Your Ref: 2023/93704
Our Ref: A000819

4th March 2024

Land northwest of Urban Terrace, Denby Lane, Grange Moor, Huddersfield – Erection of 10 dwellings and associated works

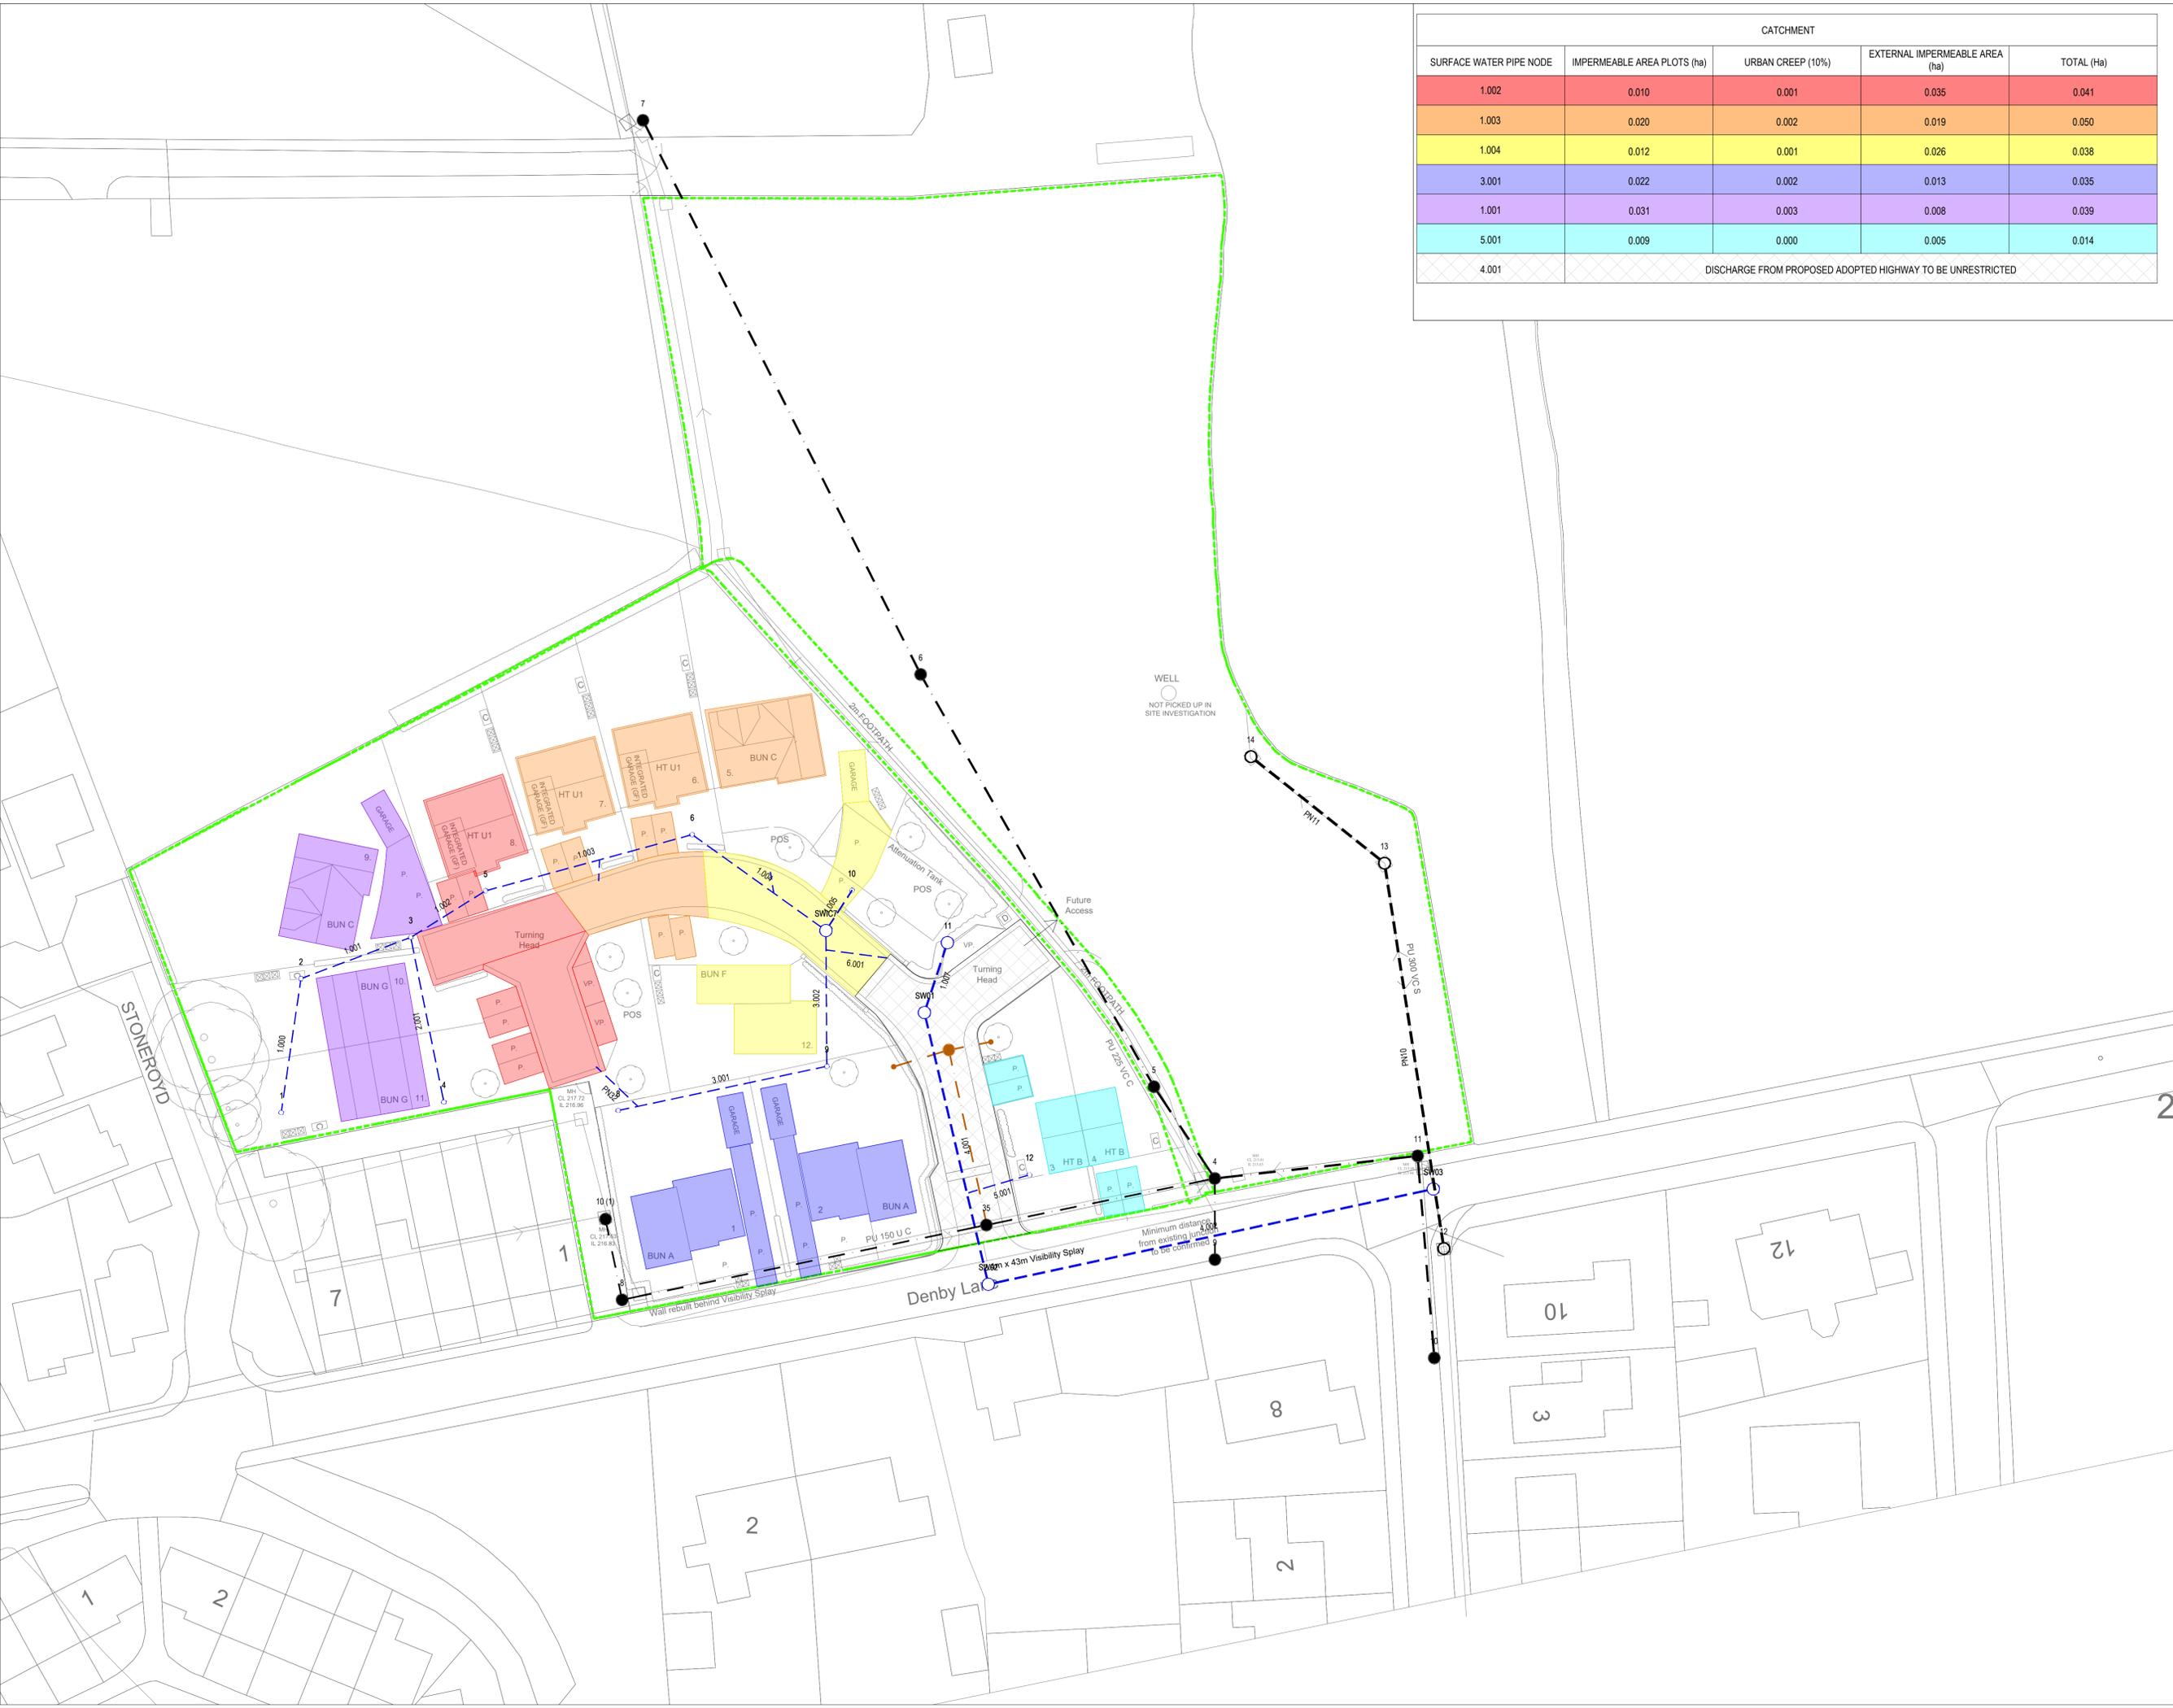
f.) The means of surface water management has not been properly considered within the FRA/drainage report. Yorkshire Water requires further information regarding the means of draining surface water from the development

2.) On the Statutory Sewer Map, there is a two 150mm diameter public combined surface water sewer recorded to cross the site. It is essential that the presence of this infrastructure is taken into account in the design of the scheme.

a.) It may not be acceptable to raise or lower ground levels over the sewer and we will not accept any inspection chambers on the sewer to be built over.

c.) In the instance of the northernmost 150mm sewer, a stand-off distance of 3 (three) metres is required at each side of the sewer centre-line and it may not be acceptable to raise or lower ground levels over the sewer, nor to restrict access to the manholes on the sewer. This stand-off distance is to be maintained through a proposal by the developer to alter/divert a public sewer will be subject to Yorkshire Water's requirements and formal procedure in accordance with Section 185 Water Industry Act 1991.

3.) The developer is proposing to discharge surface water to public sewer however, sustainable development requires appropriate surface water disposal.

a.) Yorkshire Water promote the surface water disposal hierarchy and the developer must provide evidence to demonstrate that surface water disposal via infiltration is not reasonably practical before considering disposal to public sewer.

c.) As the proposal site is currently undeveloped, no positive surface water is known to have previously discharged to the public sewer network. Surface water discharge to the existing public sewer network must only be as a last resort and the developer is required to eliminate other means of surface water disposal.

d.) As a last resort, and upon receipt of satisfactory evidence to confirm the reasons for rejection of other methods of surface water disposal, curtilage surface water may discharge to public surface water sewer at a restricted rate of 3.5 litres per second.
